Our Ref: FP/46/18/HH

Town & Country Planning Act 1990 (as amended)
Town & country Planning (Development Management Procedure) (England) Order 2015
Application for Planning Permission for Works or Extension to a Dwelling

Development Single-storey rear conservatory.

Location 119 Felpham Way Felpham

Drawing Title:
Location and Site plan

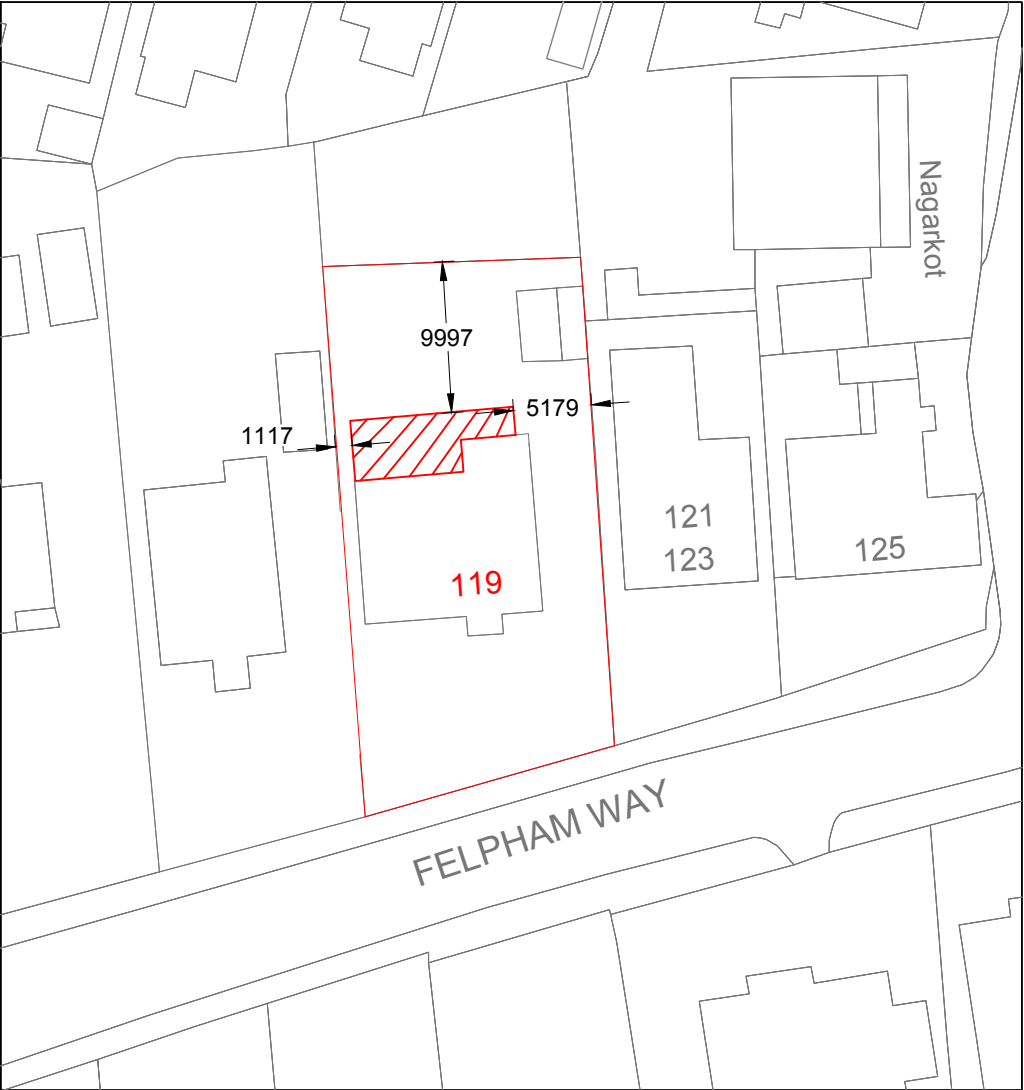
Please submit 1 electronic or 3 paper copies of a block/site plan at a scale of 1:500 or 1:200. Further details of what must be included on the plan can be found in the National Validation Requirements. Please provide a measurement from the proposal to the rear site boundary.

Existing Rear elevation

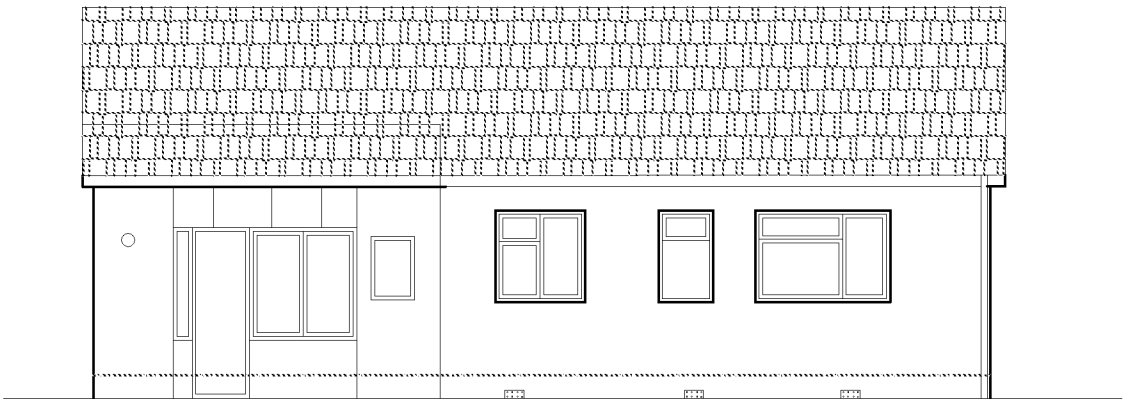
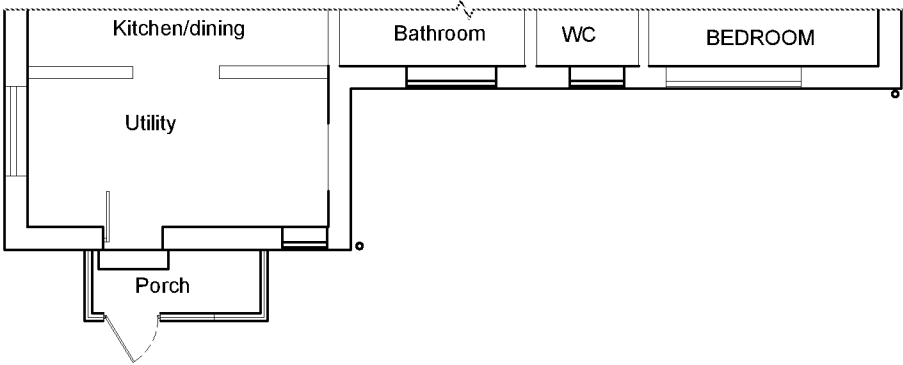
The existing rear floor plan and elevation do not accord. Please amend accordingly.

Proposed right elevation

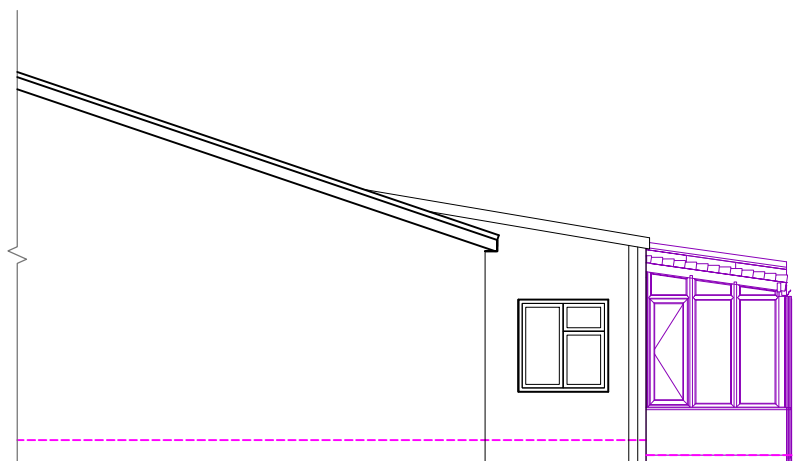
The proposed right elevation has been mislabelled. Please amend accordingly.
